Sent: 28 November 2017 13:44
To: Roger Spencer
Cc: Richard Temple; Planning.Responses; Planning; Ian D Solkin MIH
Subject: Ref Planning Application FP/268/17/PL

Thank you for your consultation response dated 21/11/17, in respect of the above planning application, the contents of which are appreciated.

PROJECT Gull Point Suites - On the Beach
TITLE Site Plan
SCALE 1 : 100
DATE 20/09/17
DRG NO IBA/480/02
REVISIONS

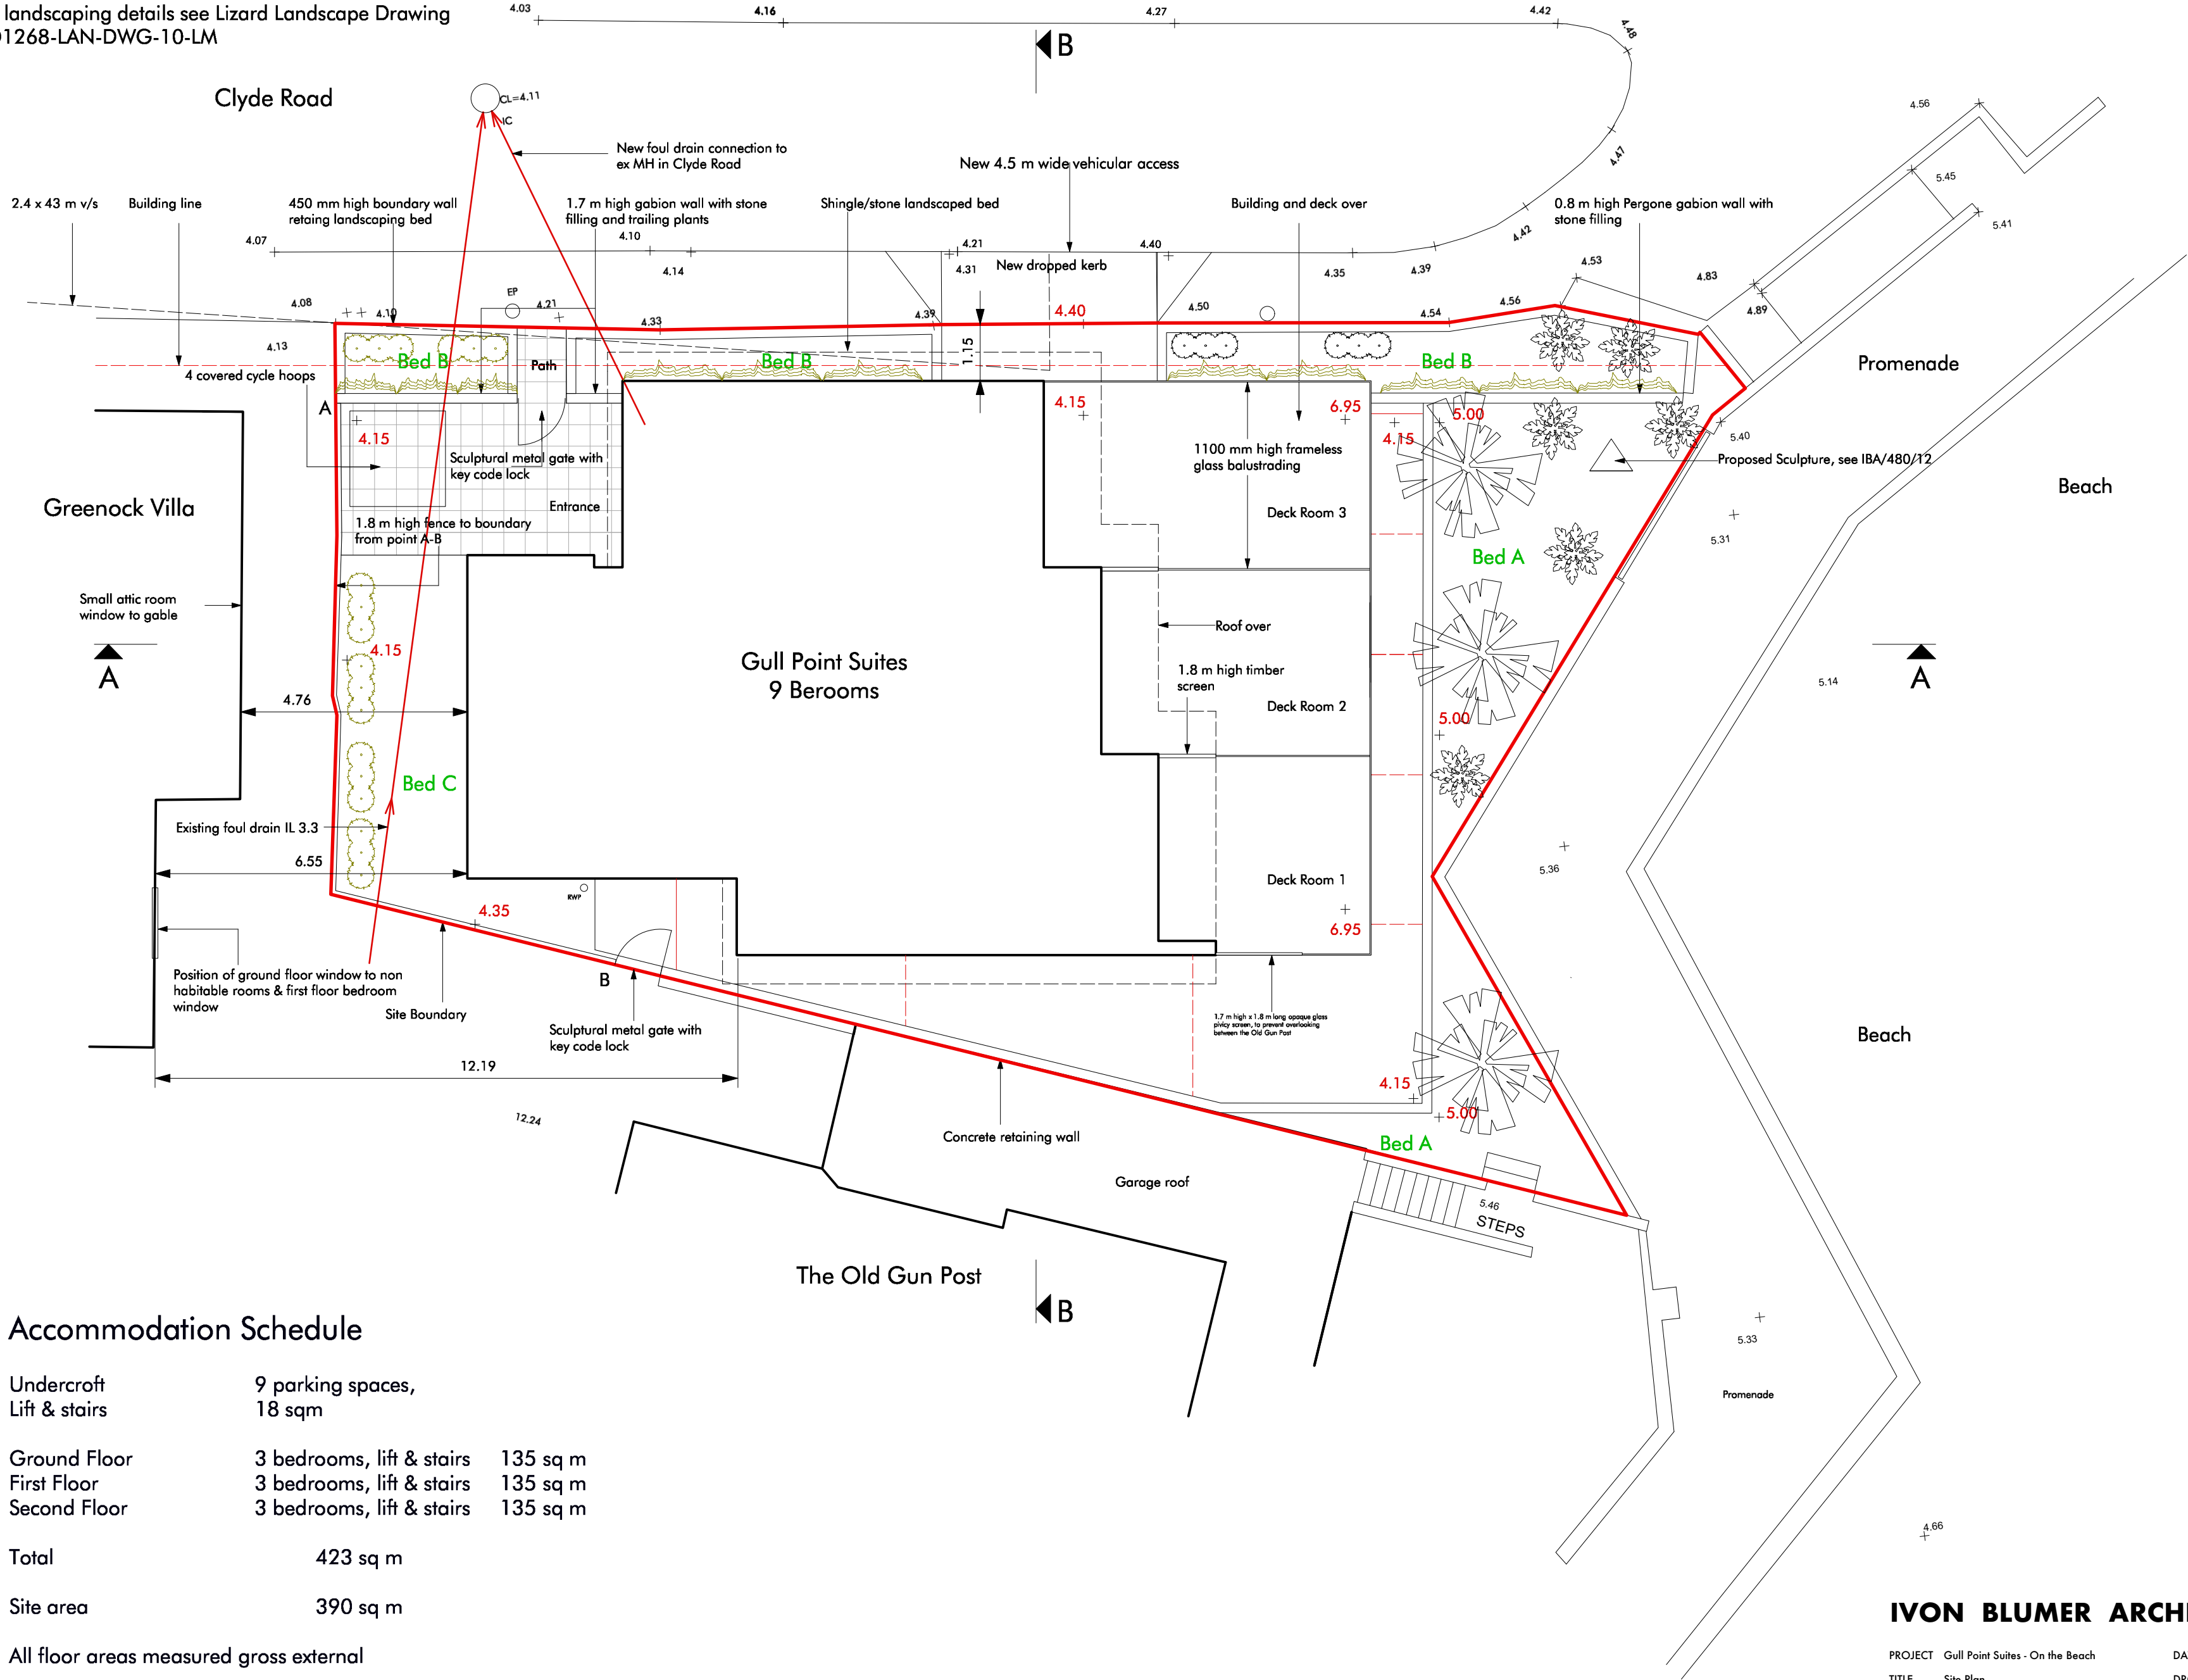
However, can I please draw your attention to our landscaping drawing and landscape design strategy, both these documents make reference to a hardwood timber wall behind the existing sea defence wall, within our landscaped area along the eastern boundary, to act as a secondary line of defence. This timber wall will be slightly set back from the existing sea defence wall at the back of the promenade and will be some 500 mm higher than the existing sea defence wall.

PROPOSED LOW TIMBER WALL

Proposed low hardwood timber wall reflecting
context of beachfront location and materials
would provide visual enclosure, define the
boundary and increase the protection of the site.
